West Grange, Grange Park,  
Steeple Aston,  
Oxfordshire OX25 4SR

**OBJECTION TO PLANNING APPLICATION  
REF 11/00114/F AND 11/00115/CAC: WINCOTE, COW LANE, STEEPLE ASTON**

View 01 as existing

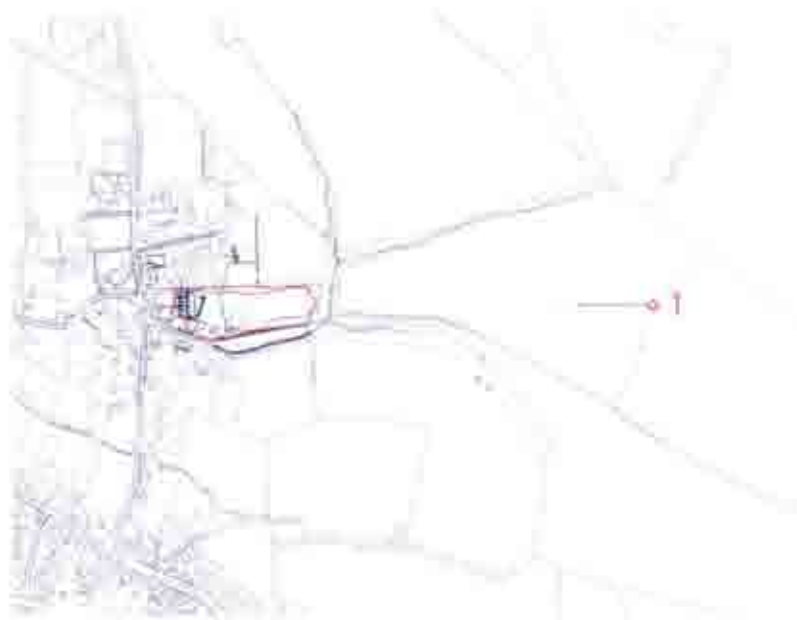
1.8 It is also worth noting, in passing, that the applicants pay great attention to the Rousham "Eye Catcher". This was designed by William Kent as a folly, deliberately standing out on the hill-side. The orientation of the proposed development ensures that the Eye Catcher will be seen from its windows. View 01 on p.31 of the Statement document makes this clear. If the photo had been taken from the other side of the Eye Catcher, instead of being obscured by it the development would be clearly visible. One Eye Catcher looking across to another, both of them follies.

View 03 as existing

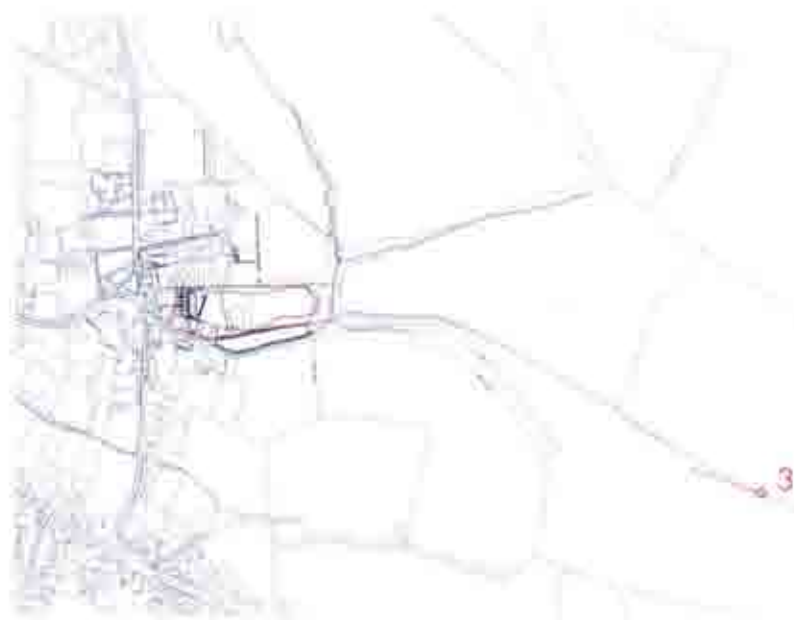
The only attempt to face up to this important issue is illustrated on p.35 of the Planning, Design and Access Statement, where View 03 appears to show that only a small portion of the East elevation would be visible, peeping through the trees below the church tower.

1.5 This montage is, in our view, misleading. The view is of summer trees, in full foliage. In winter it is very likely that a much greater extent of the elevation will be visible. This might not be an issue if the elevation in question were not so extraordinary. Presumably because of the applicants wish to keep the building low, it has become very long instead. It is twice the length of, for example, the main elevation of Aston House nearby across Cow Lane. In addition, and of crucial importance, the applicants have chosen to orientate the building East-West rather than North-South (as is Aston House, and indeed the Longbyre next door to the site- both new buildings given approval in recent years). The existing building of Wincote is not visible through the trees, even in winter, and this is because it is South-facing. The decision to place the double-length elevation facing East maximises its views out across the Cherwell Valley. But by the same token, that decision exposes the façade to view from the Valley.

1.7 It is interesting to compare the applicant's drawing of the East elevation, below, to their rendition of it peeping through the trees in View 03. It might be thought that its appearance there, in deep shadow, is deliberately muted, whereas with full sun on it in the mornings the façade might be nearer in appearance to the Elevation drawing itself, as indicated in our montage. It is difficult to be sure, but there must be sufficient doubt about this to render it a major concern. It is a concern because it will be seen, from Cow Lane, and from further across the Valley, directly below the Church tower, as the applicants' own montage makes clear.
